REFUSAL OF PLANNING PERMISSION

APPLICATION NO. 2014/0183

Proposal Erection of 1 no. detached bungalow.
At 22 Abbey Lane, Barnsley, South Yorkshire, S71 5QD

Drawing Title
SITE PLANS

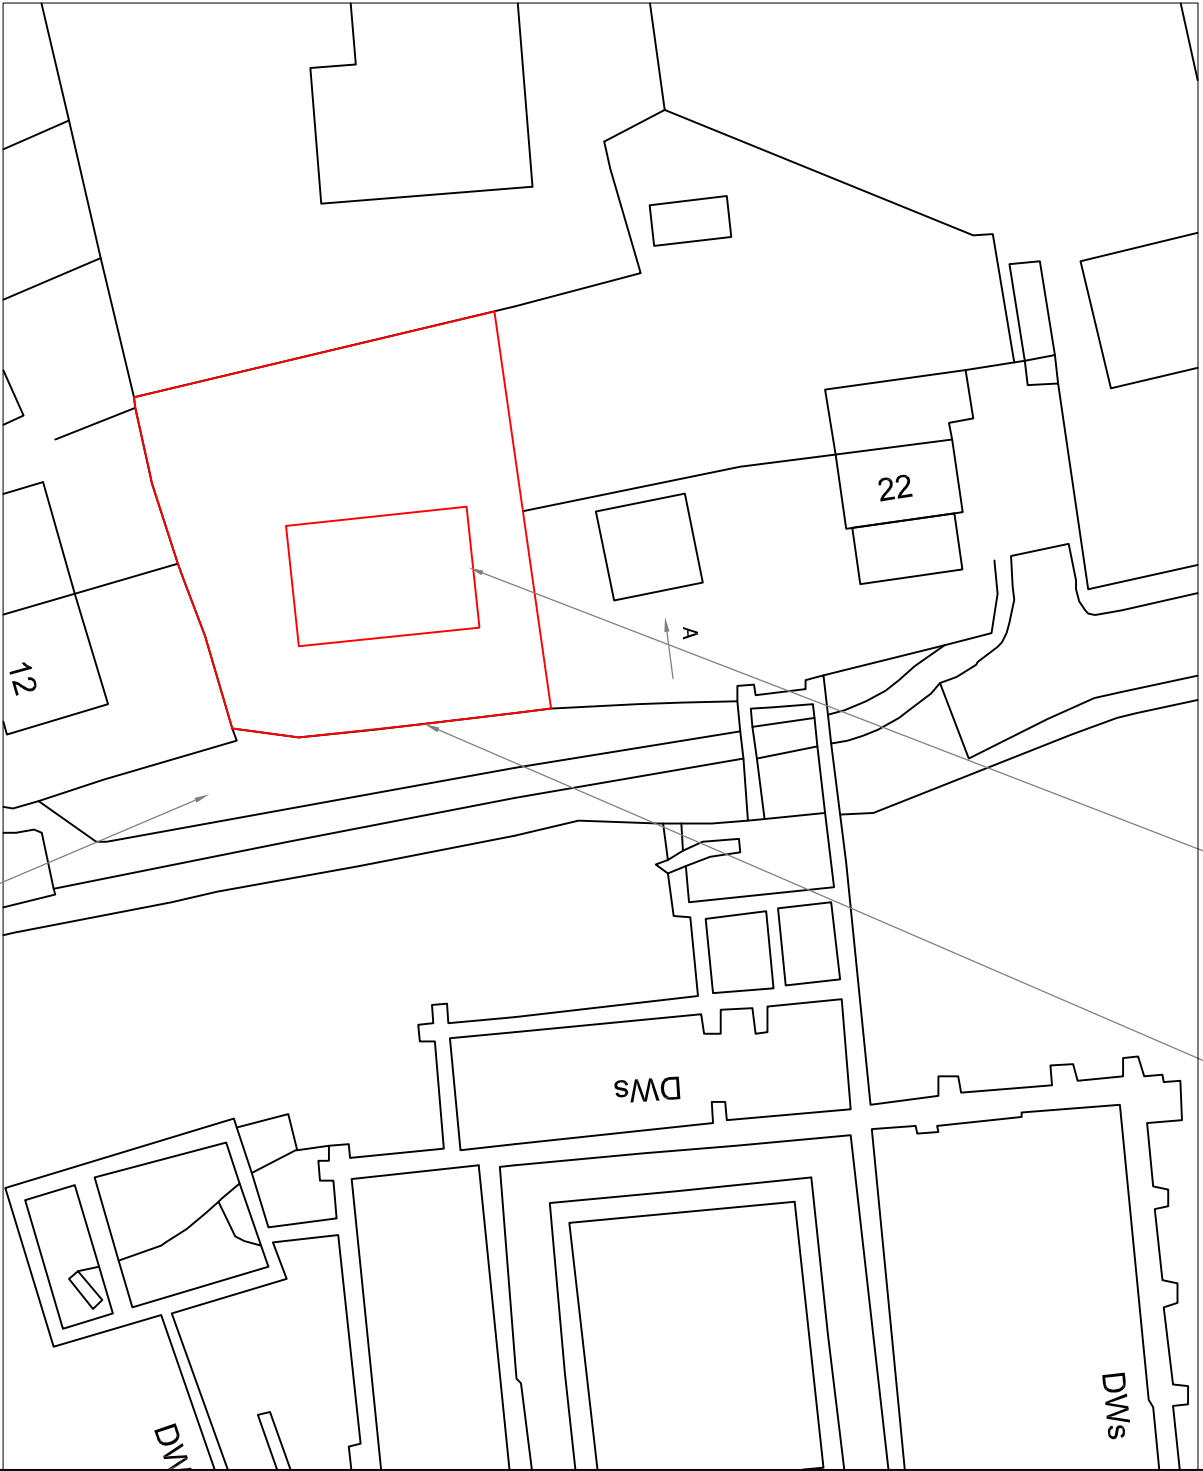
- 2 The access required to serve the dwelling is outside of the applicant's control. In addition, the plans and specifications provided with the application fail to demonstrate that there would not be a conflict between the vehicles using the proposed access and the pedestrians utilising the relocated footpath. Consequently, the proposal would be likely to reduce highway safety to an unreasonable degree, contrary to CSP 26 and H8D.

Drawing Title
PROPOSED ELEVATIONS

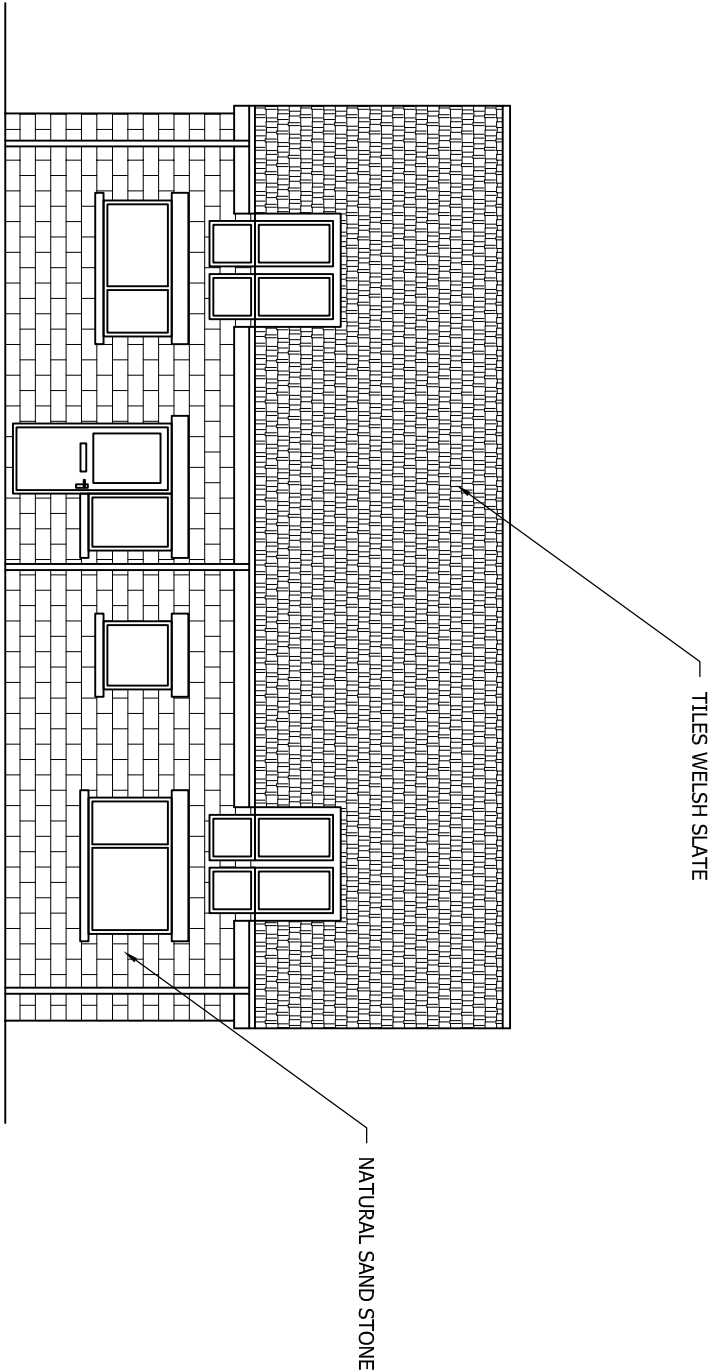
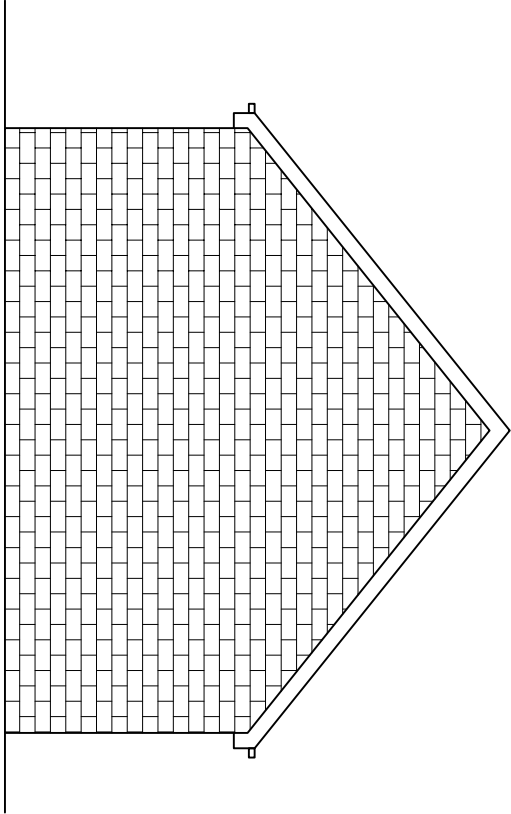
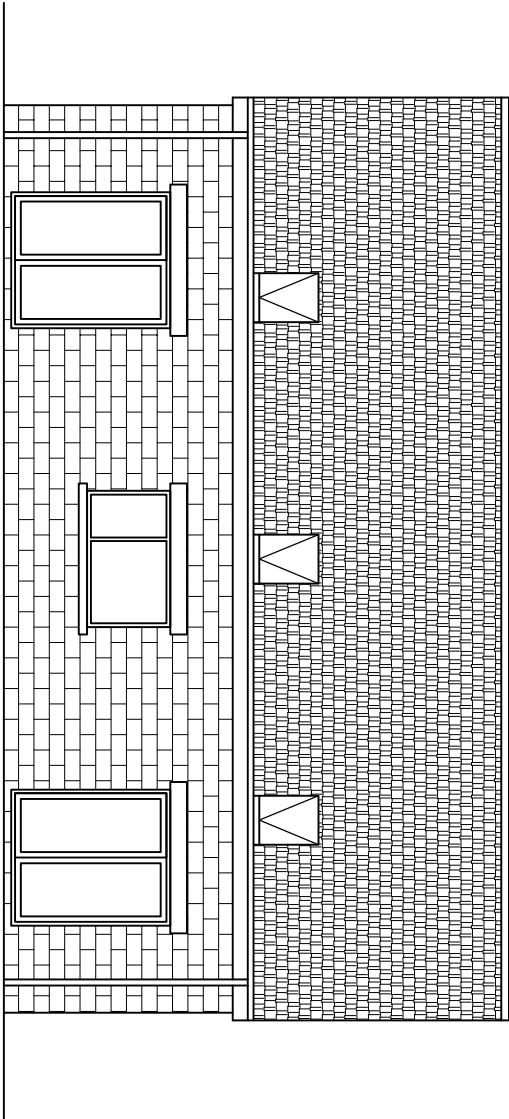
- 1 In the opinion of the Local Planning Authority the proposed dwelling and access would be contrary to Policy H8D of the Unitary Development Plan, policies CSP 29 and CSP 30 of the Core Strategy and the Council's Supplementary Planning Document 'Designing New Housing Development' in that their design would be architecturally inconsistent with the character of the area. In addition, their proximity to a Scheduled Ancient Monument and listed buildings would fail to preserve or improve the character/appearance of the heritage assets, contrary to CSP 30.
